# Hayes Park, Hayes End Road, Hayes, UB4 8FE

## Transport Note - Response to GLA and Highway Authority Comments (Planning Ref: 12853/APP/2023/1492)

**Date:** September 2023

**Document Reference:** WIE19060.112.R.1.1.3.TN

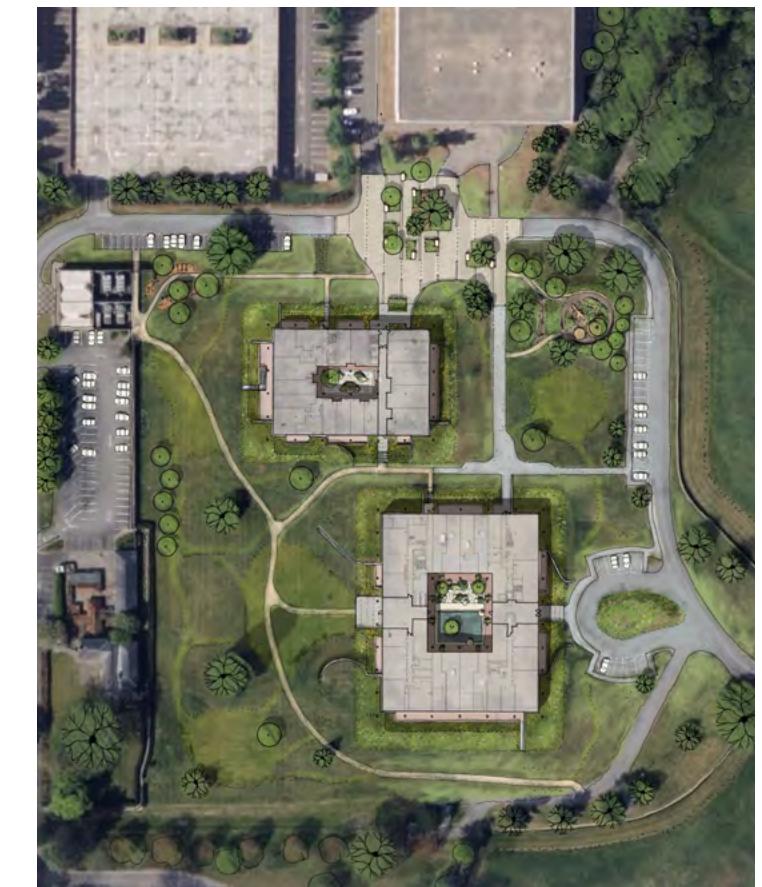
*'Access routes between all disabled parking and main entrances should be revised to be continuous and direct, and it should be ensured that all pedestrian routes within the site will be safe and attractive to use at all times.'*

- 2.13. The GLA request to provide direct walking routes between all disabled parking bays and main entrances has been achieved. There is a direct and continuous route between disabled parking bays and the two proposed blocks. The routes are flat and step free. As requested by GLA, a direct and continuous footway will be provided from the three disabled bays at the north of the site to connect to the pedestrian route (P05) towards the central block. A copy of the revised landscape plan is included within Annex B.
